**City of Portland, Maine - Building or Use Permit Application**

<b>Permit No:</b> 10-0329		<b>Issue Date:</b>		<b>CBL:</b> 224A A001001	
<b>Location of Construction:</b> 660 BRIGHTON AVE		<b>Owner Name:</b> ATH REALTY LLC		<b>Owner Address:</b> 16 EQUESTRAIN WAY	
<b>Business Name:</b>		<b>Contractor Name:</b> Burr Signs		<b>Contractor Address:</b> 50 DownEast Drive Yarmouth	
<b>Lessee/Buyer's Name</b>		<b>Phone:</b>		<b>Phone:</b> 2077991183	
<b>Past Use:</b> Commercial - Funeral Home		<b>Proposed Use:</b> Commercial - Funeral Home - install a 35" x75" freestanding sign		<b>Permit Type:</b> Signs - Permanent	
<b>Proposed Project Description:</b> install a 35" x75" freestanding sign		<b>Permit Fee:</b> \$66.00		<b>Cost of Work:</b> \$66.00	
		<b>FIRE DEPT:</b> <input type="checkbox"/> Approved <input type="checkbox"/> Denied		<b>INSPECTION:</b> Use Group: Type:	
		Signature:		Signature:	
		<b>PEDESTRIAN ACTIVITIES DISTRICT (P.A.D.)</b>			
		Action: <input type="checkbox"/> Approved <input type="checkbox"/> Approved w/Conditions <input type="checkbox"/> Denied

<b>Location of Construction:</b> 660 BRIGHTON AVE	<b>Owner Name:</b> ATH REALTY LLC	<b>Owner Address:</b> 16 EQUESTRAIN WA

PROPOSED NEW SIGN LOCATION  
1" = 10'-0"

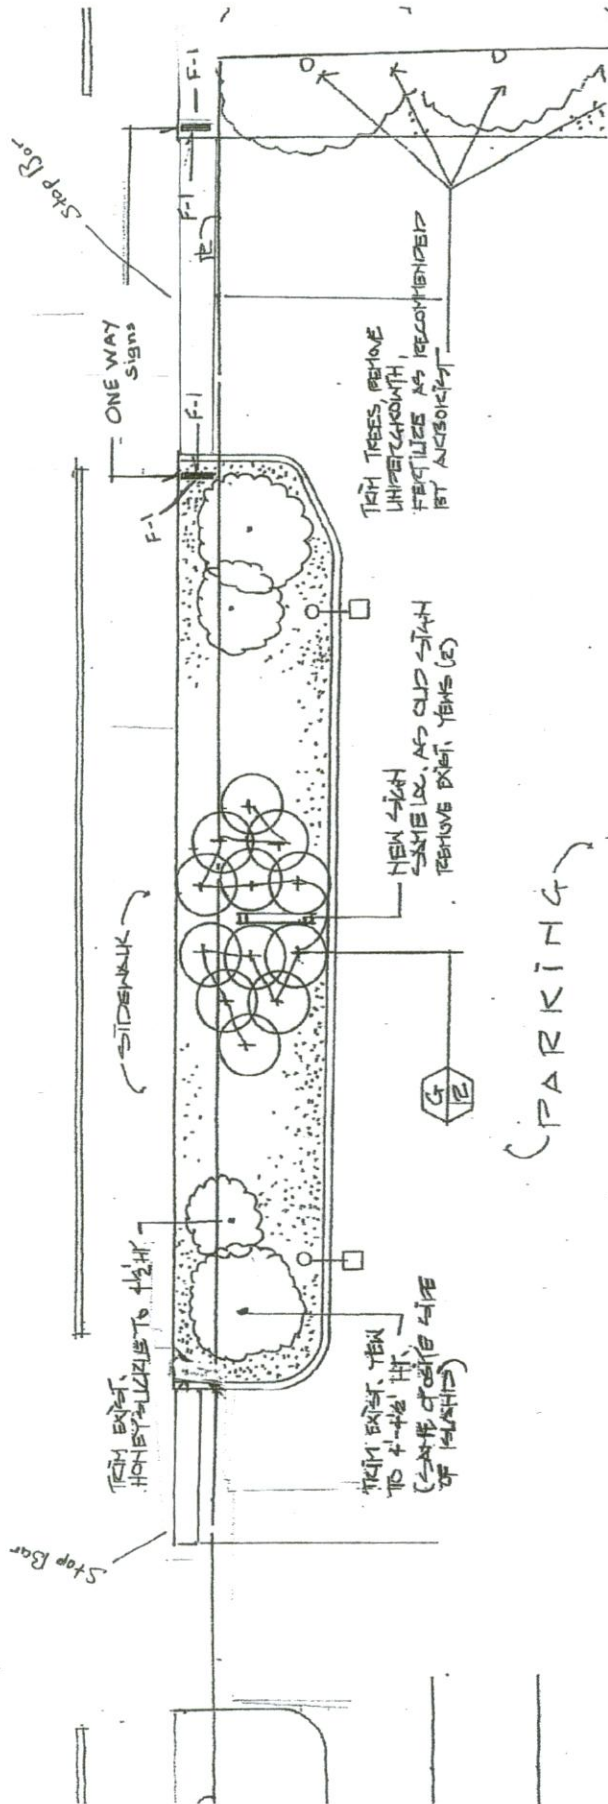
4/5/2010-mes: received the certificate of insurance on this date - gave to Shukria in planning for "variance" review for the setback of 1' instead of the 5' required.

4/8/2010-mes: I picked up the permit from Shukria after she signed off - Tom Errico (traffic engineer) reviewed the plans at yesterdays site plan review meeting and did not have a problem with the placement of the sign

4/8/2010-jmb: Spoke to Kristy at Burr Sign to verify how the sign is anchored. There will be 3" poles on either side down 4' into concrete. The sign is trimmed out on top of masonry ( by others).
